Consultation Response from KC, Highways Development Management (HDM)		
2025/92160 - Grange Moor Coachworks, Barnsley Road, Grange Moor, Huddersfield, WF4 4DR		
Discharge of details reserved by Conditions 24 (Surface Water Strategy), 25 (Exceedance), 26 (Temp Surface Water), 27 (Interceptor), 29 (Sewer Easement), 30 (Foul Water), 31 (Archaeological Investigation), 34 (Road Condition Survey), 35 (CTMP), 40 (Retaining Walls), 41 (Travel Plan) on previous permission 2023/90668 for demolition of existing buildings; erection and operation of single building comprising Sui Generis land use limited to the purpose of storage, assembly, sale and distribution of custom-built computers, laptops and their components as well as any associated development (those being a replacement wind turbine, utility provision, drainage, access, hard and soft landscaping) within the red-line boundary alongside business operations pursuant to the effective administration of the Sui Generis use

Date Responded: 18/09/25	Responding Officer: A Darwin	Responding Ref: HDC 16-5/1

RECOMMENDATION: Further information and amendments are required in relation to Condition 34, 35 and 41. Therefore, it is recommended that

Client	ACUMEN
Project	PC SPECIALIST GRANGE MOOR
File	Proposed External Works
Drawn	STP
Checked	SAB
Date	April 2025
Scale	1:250
Original by/for	AO
Drawing Number	P3849-DR-02
Rev	P01

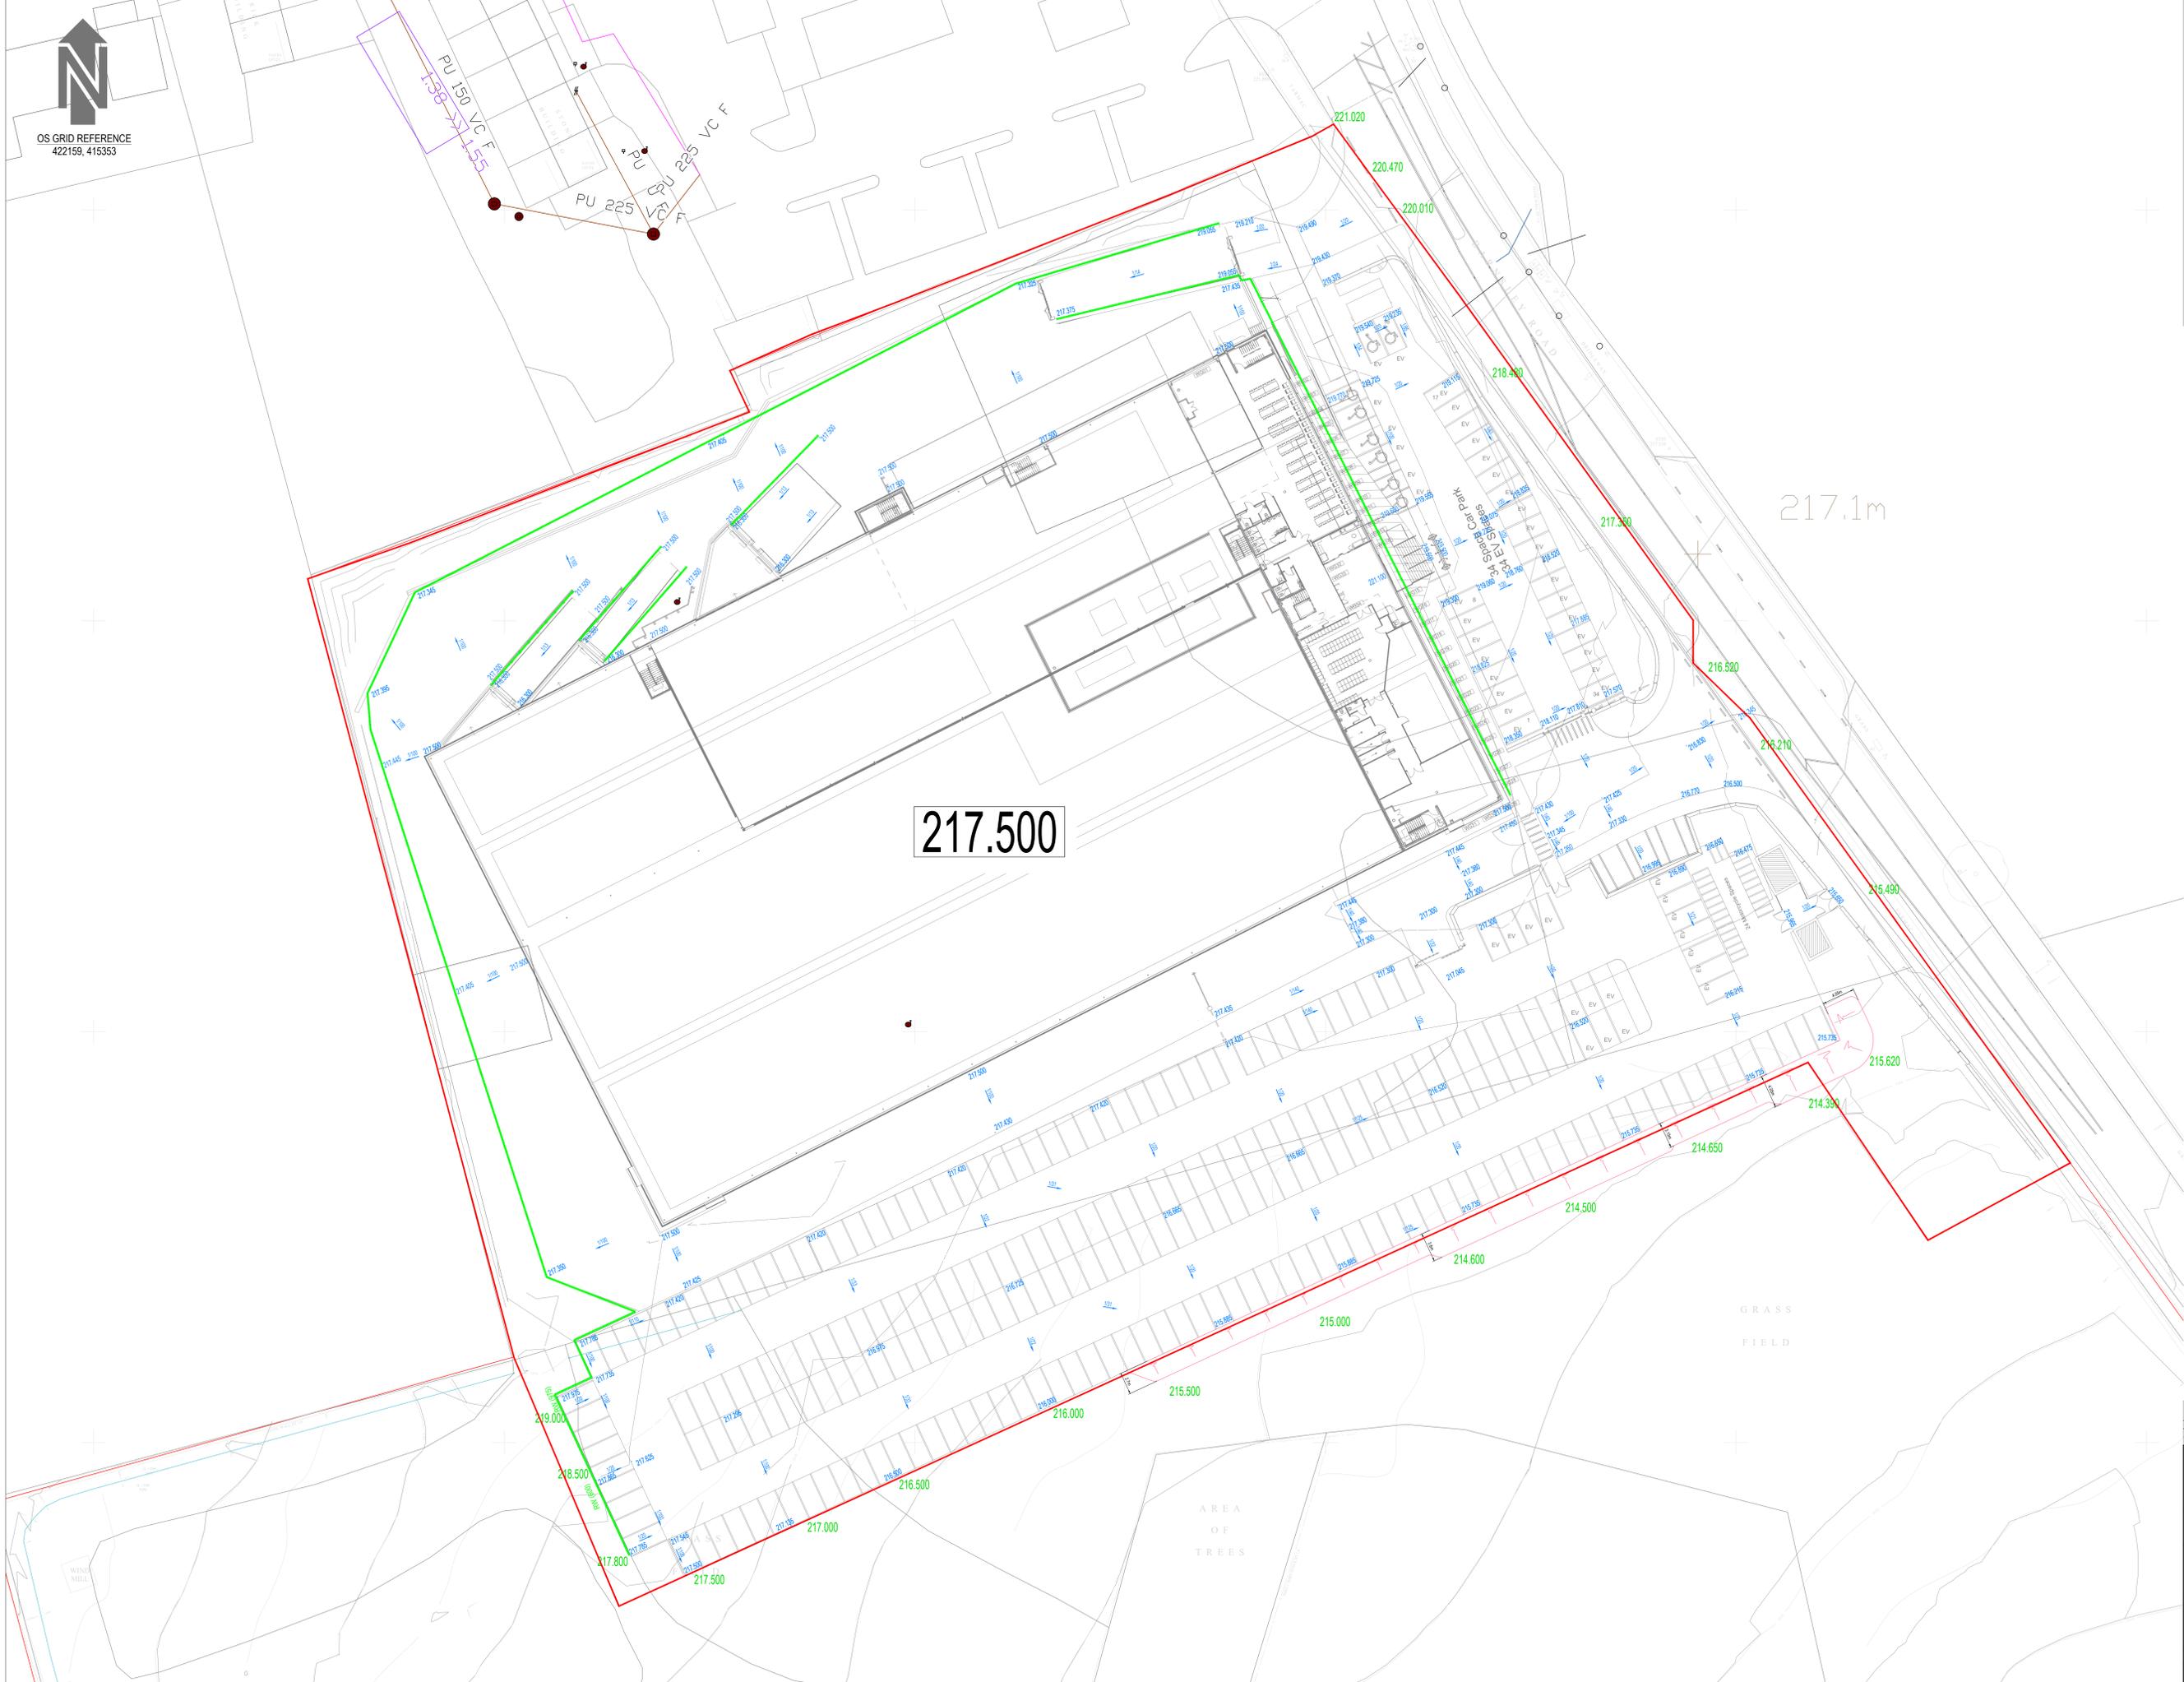
*'Based on the information provided on drawing no P3849-DR-02 Rev P01 - Proposed External Works, the design of new retaining walls at this site are not considered to impact the highway or the safety of highway users and as such outside the remit of my consideration.
In view of the above, Condition 40 (retaining walls) can be discharged.'*

In light of the above, HDM recommend that Condition 40 can be discharged.
